Case Reference: EN010159

Application by One Earth Solar Farm Limited for a Development Consent Order for the One Earth Solar Farm

RESPONSE OF MR RAY ARMSTRONG TO THE SECRETARY OF STATE'S INVITATION TO COMMENT ON THE PUBLISHED RESPONSES

Figure 2.4: Wind Rose for North Clifton, Nottinghamshire

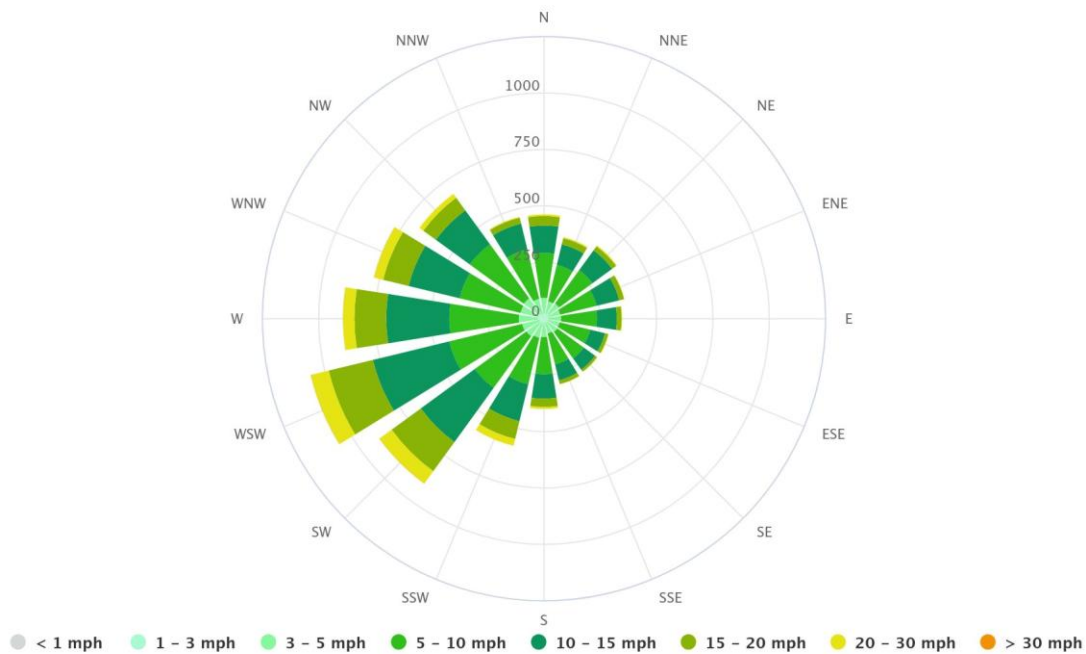
The difficulty with presenting outcomes by reference to "90% of meteorological conditions" is obvious: it leaves unanswered what happens in the remaining conditions, including conditions in which emissions, smoke, particulates or fire-related contaminants may travel towards water infrastructure, homes or other receptors.

In a case involving a large BESS beside drinking-water infrastructure, it is not good enough to rely on a broadly favourable generalisation about likely wind direction or typical conditions. The issue is the consequence of a serious incident if less favourable conditions occur. That is especially so where the site lies within a protected drinking-water catchment and where the treatment works and reservoir are in close proximity.

*Figure C.2: Impacts from Unplanned Emissions at Eastern BESS Compound*

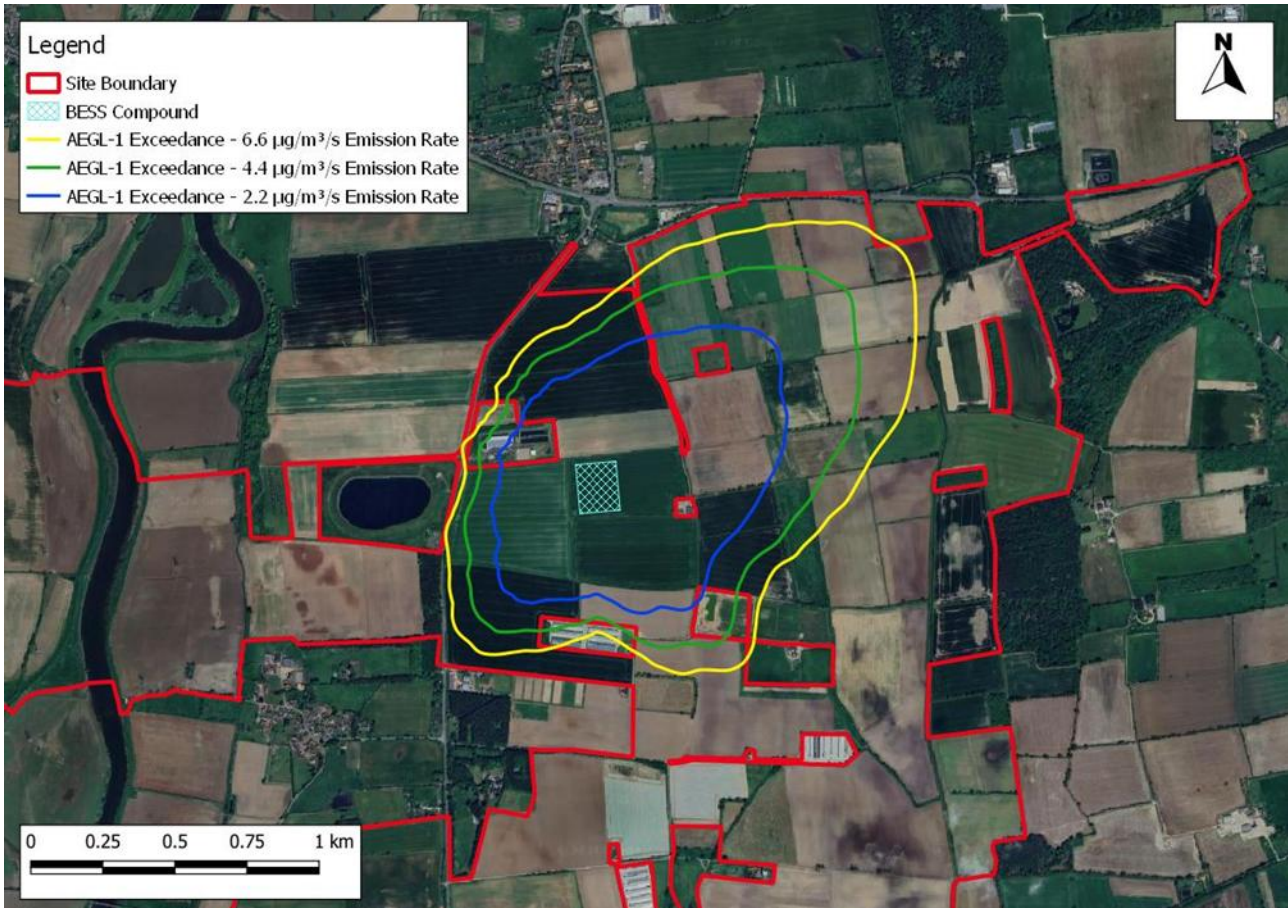
In my earlier submission, I highlighted the Applicant's statement in the Outline Battery Safety Management Plan that, at the eastern BESS site, there are no sensitive receptors within the area where assessment levels may be exceeded in 90% of meteorological conditions, and therefore no significant adverse health effects are anticipated. I remain concerned that this presents the issue in an unduly reassuring way.

The eastern BESS is not located in an empty landscape. Sensitive receptors in the surrounding area include, among other things:

- the **North Clifton drinking water treatment plant**;
- **North Clifton Reservoir**;
- homes and settlements including **North Clifton village**;
- nearby roads and businesses;
- poultry units and agricultural receptors; and
- the wider protected water environment.
